Replace existing conservatory with single storey living room extension & replace existing porch with new

Jericho 188 Hawthorn Road Bognor Regis

Thank you for your internet representation made on 19th April 2013 which has been recorded as '**an objection**' with the comments as follows:

PROPOSED REAR ELEV. N/W

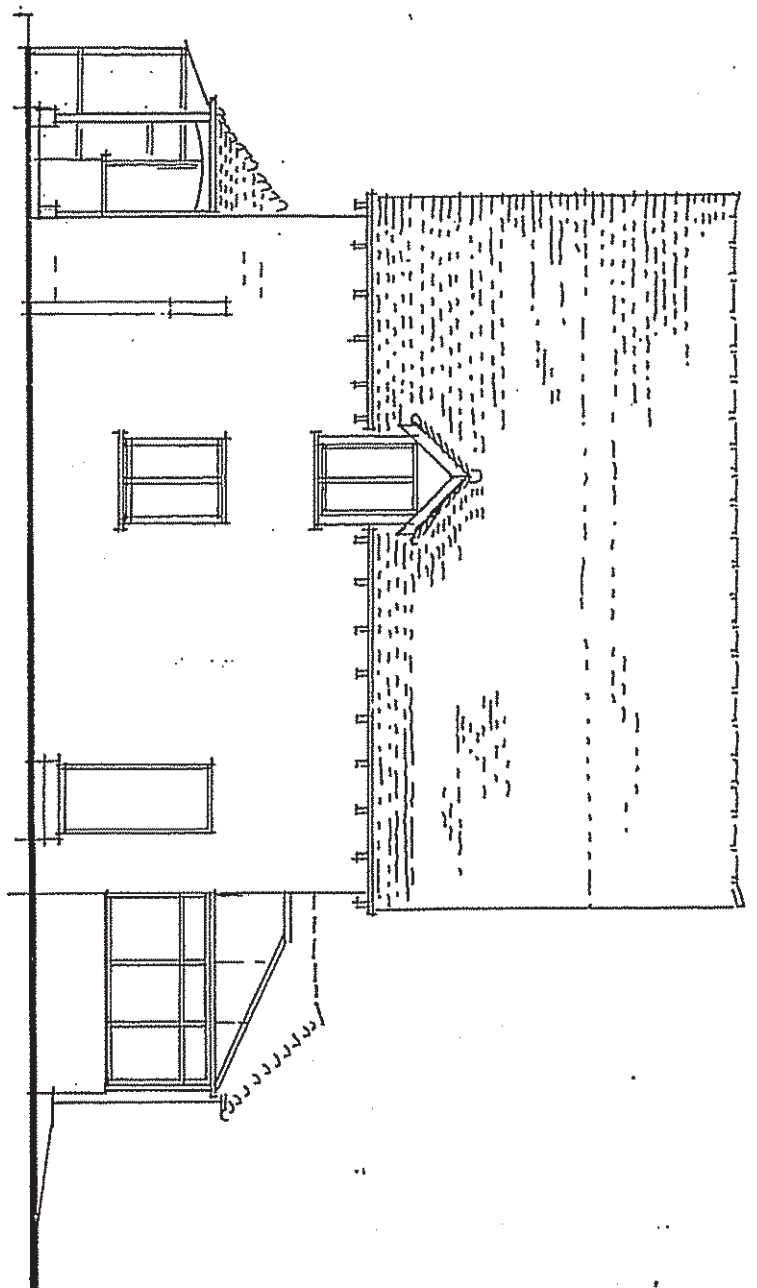
The proposed extension of the rear conservatory is going to impact on the amount of sunlight to our patio area. The height of the new extension would make our patio shady thereby affect our lifestyle. The existing conservatory does not prevent sunlight but the solid construction of the new extension will have a considerable impact on us using our patio all summer.
